From: Paul Cann
Sent: 15 May 2017 12:12
To: Planning.Responses
Subject: RE: Planning Consultation on AL/50/17/DOC

APPLICATION NO: AL/50/17/DOC

Site Address: Land West of Fontwell Avenue Fontwell Avenue Eastergate
PO20 3RU

Description of Works: Application for approval of details reserved by condition imposed under AL/121/16/PL relating to conditions 4-surface water drainage, 5-scheme for protecting proposed dwellings from noise & 6-scheme to deal with contamination risk.

Client	Mr Duggin
Drawing Title	Surface Water Drainage

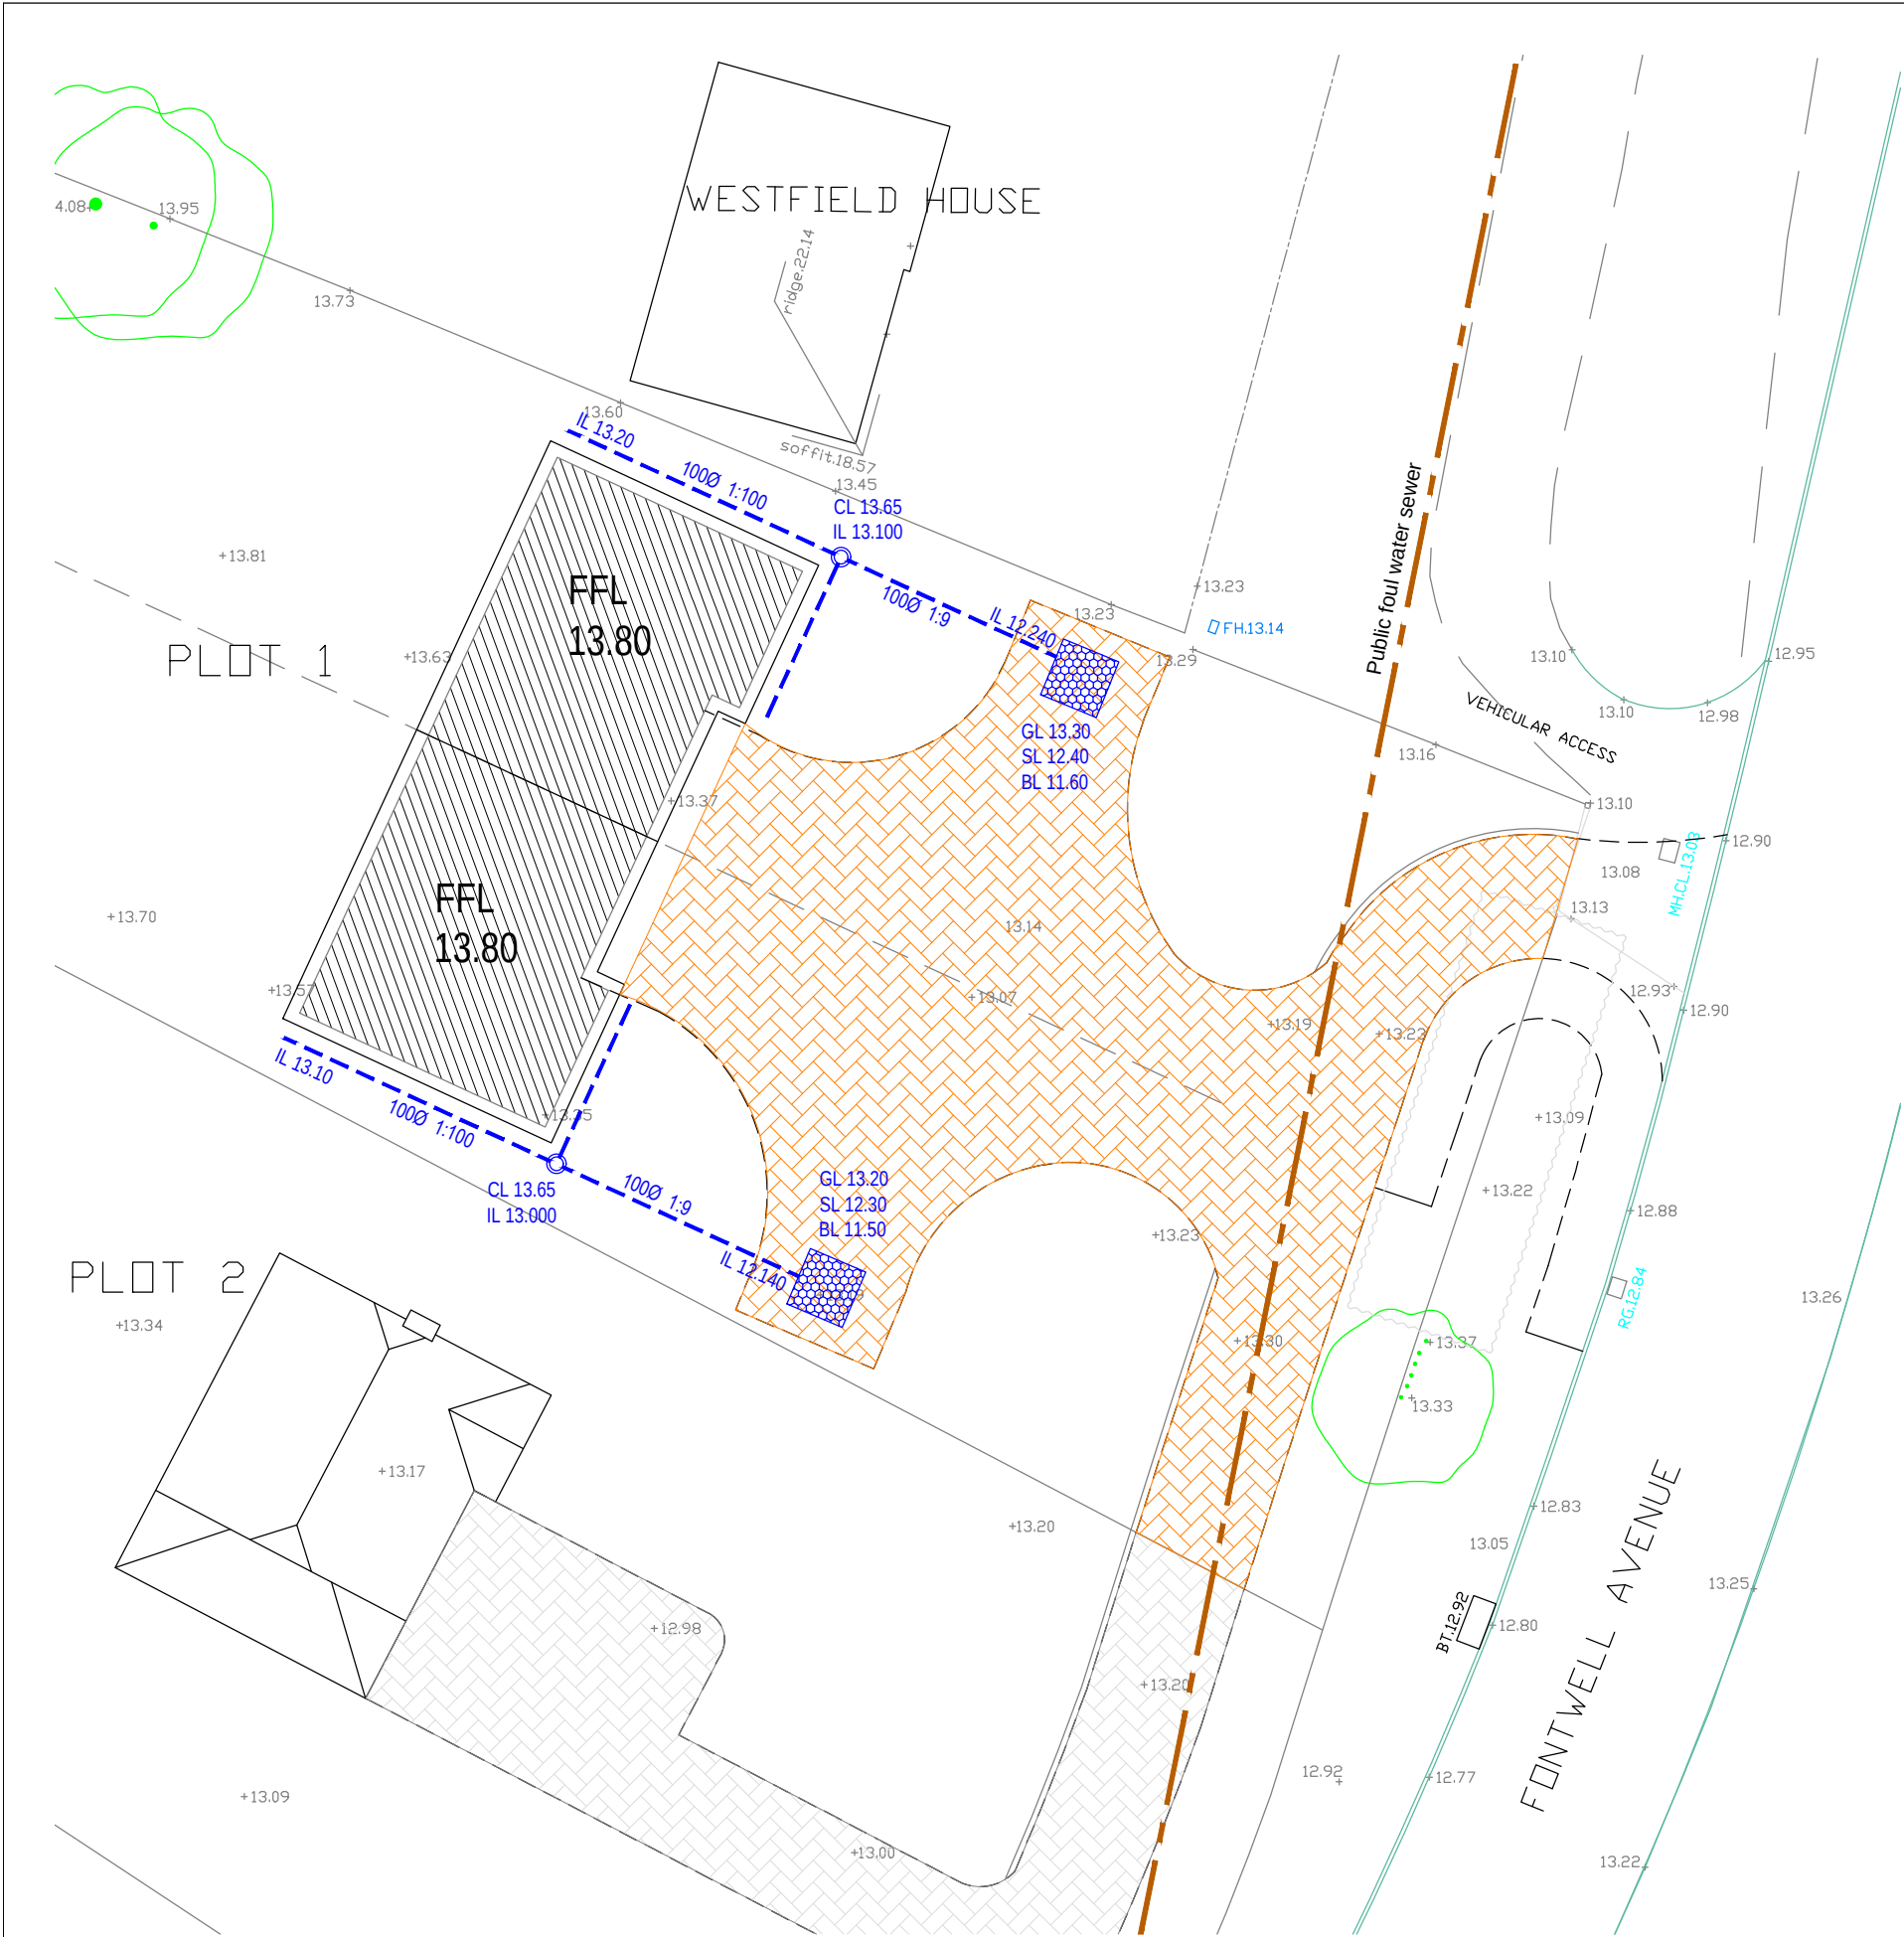
To support the proposal, the applicant needs to provide construction details (cross section) for the crated soakaways/permeable paving, to include all relevant levels of incoming pipes, etc. Silt trap manhole detail is also to be provided. Hydraulic calculations should also be supplied.
